A57 Link Roads

TR010034

**9.25 Statement of Common Ground with
Derbyshire County Council**

**Table 3.1: Statement of Common Ground (SoCG) Between National Highways and Derbyshire County Council (DCC)
 Table of Issues/Matters - Final Version dated 27 April 2022**

**Figure 8.1 - Statutory Designated Sites for Nature  
Conservation**

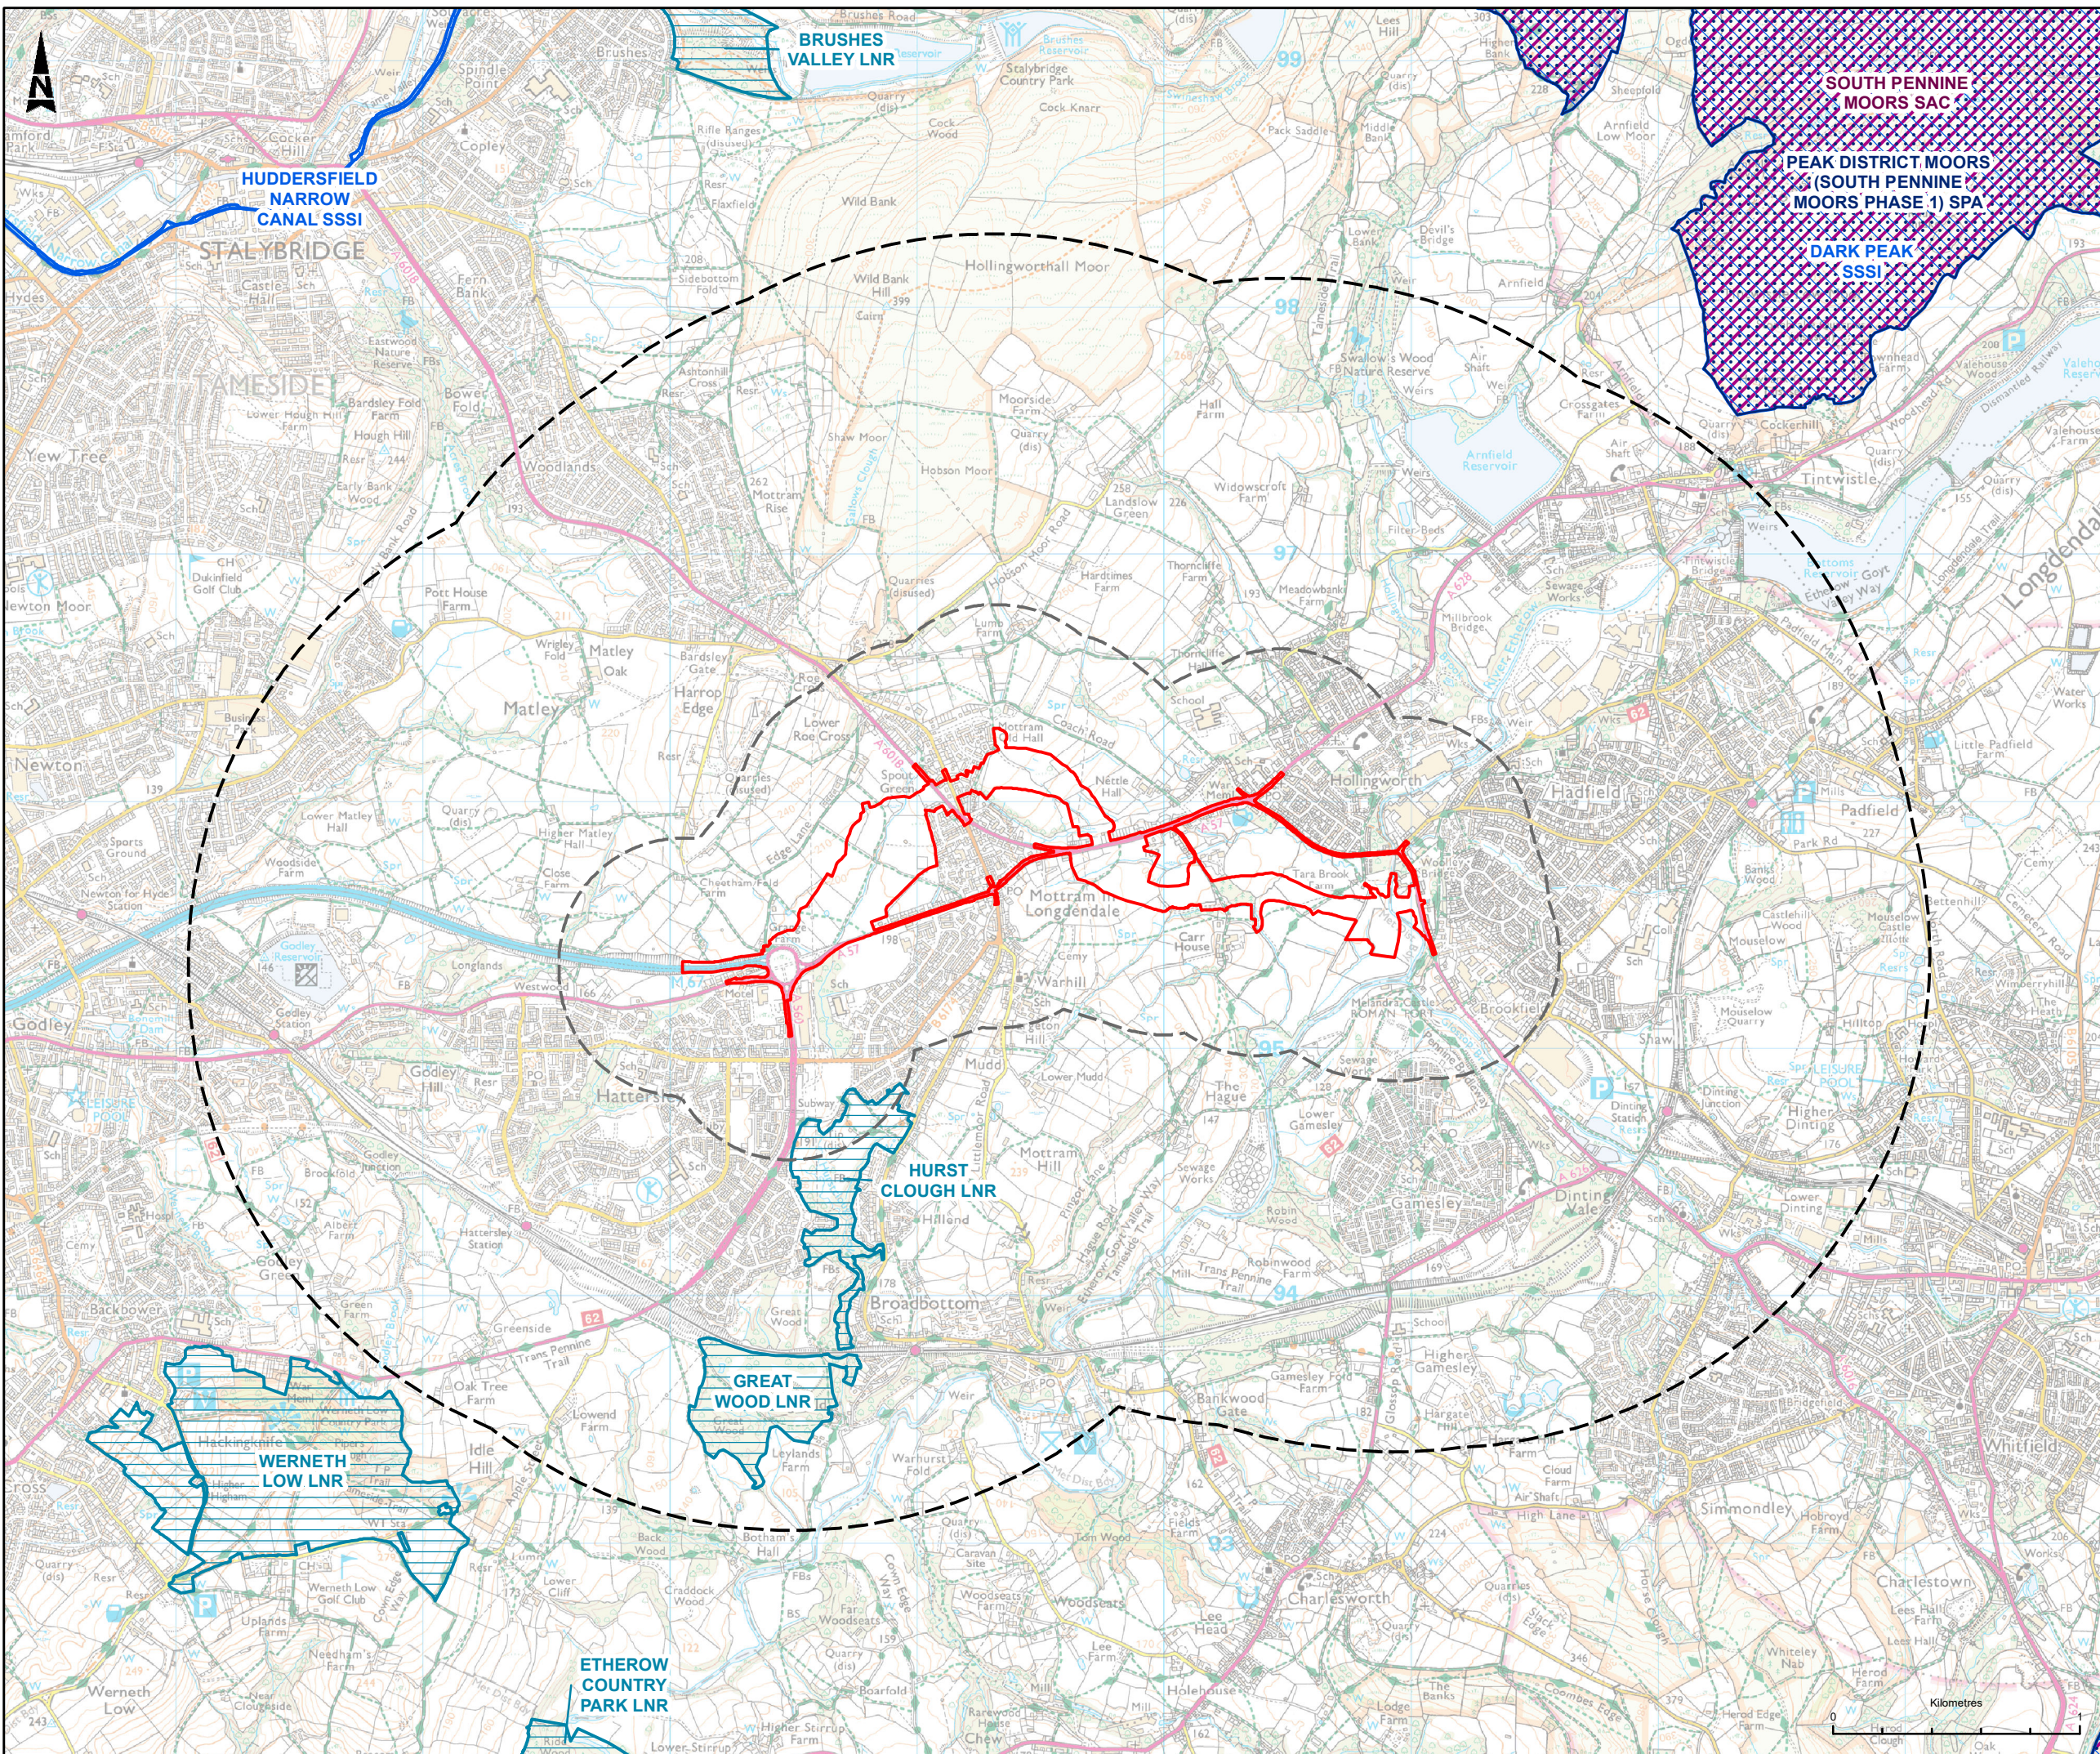
SoCG Ref. Number	Relevant examination document	Relevant Issue	DCC Comment	National Highways response	Status
	8 - Biodiversity [APP-064]	Surveys			
3.8	Environmental Statement (ES) Chapter 8 - Biodiversity [APP-064]	Biodiversity Methodology Designated sites	The Consultee stated that no part of the Scheme's RLB in Derbyshire appears to be covered by ecological designations nor supports records for notable species. Notes that non-statutory designated sites can be found nearby.	Applicant noted	Agreed
